May 19, 2010

CBL: 033 D020001
Located at 255 OXFORD ST

Notice of Violation

Drawing file: 255 Oxford Street2 / 5-17-10 Pictures.pdf

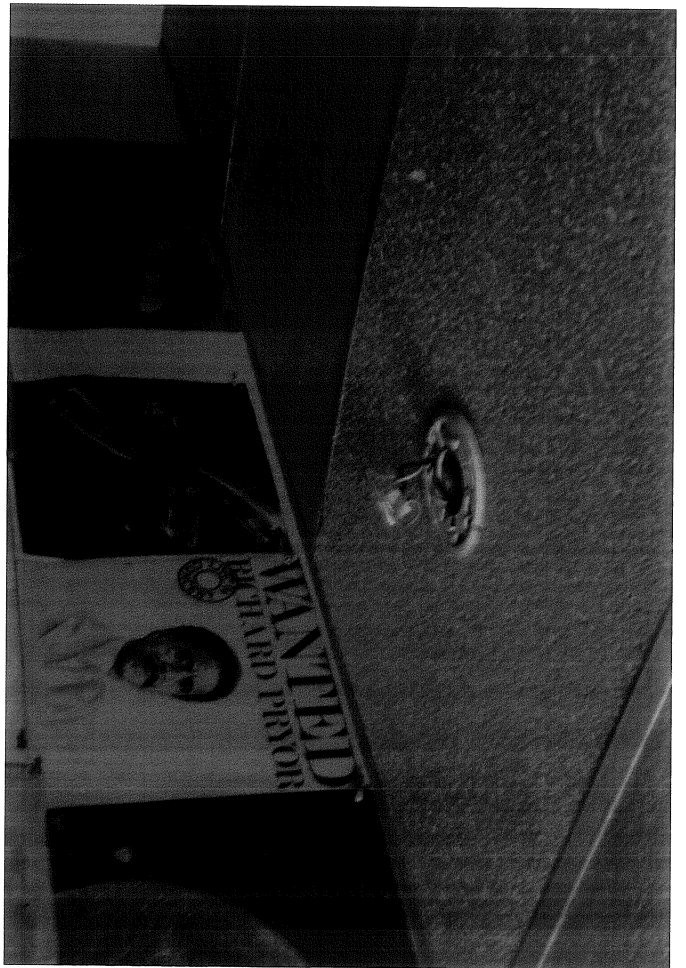
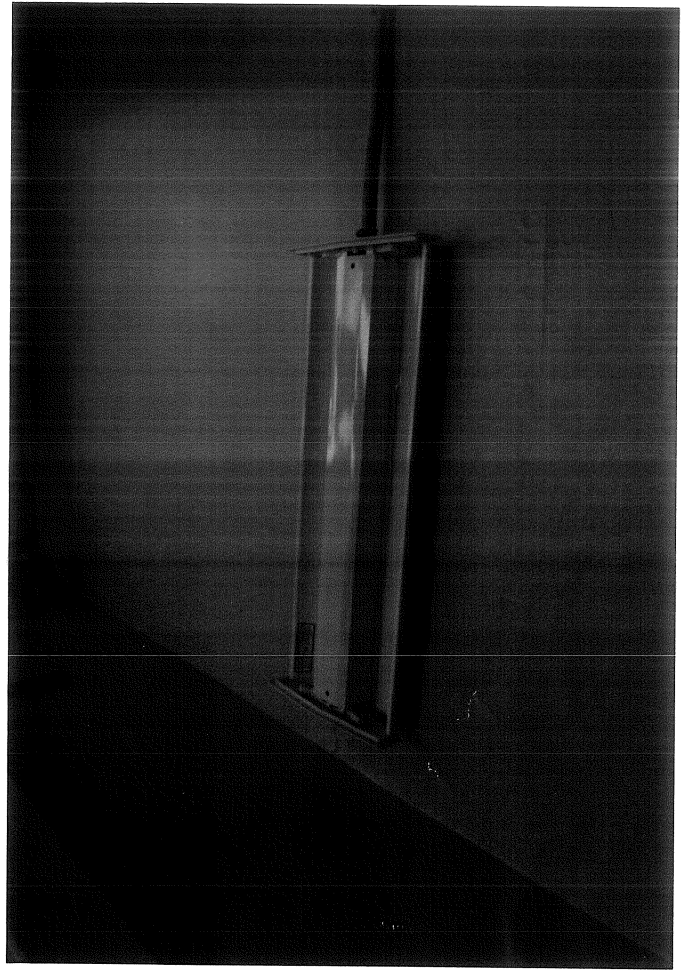
2) 6-109.(b)	Interior			Various locations	
Violation:	Maintenance of shared areas.				
Notes:	Clear all egresses and common areas (at all times) so that they are safe to travel in the event of an emergency; this shall include all common areas, stairways, exit passageways and basement storage, see attached photos.

3) 6-109.(a)	Interior			Various locations	
Violation:	Maintenance of assigned areas				
Notes:	Every occupant of a dwelling unit shall maintain in a clean and sanitary manner that part of the dwelling unit which he or she occupies and controls. This shall include removing all accumulation of trash and debris on the floors, hallways, etc., see attached photos.
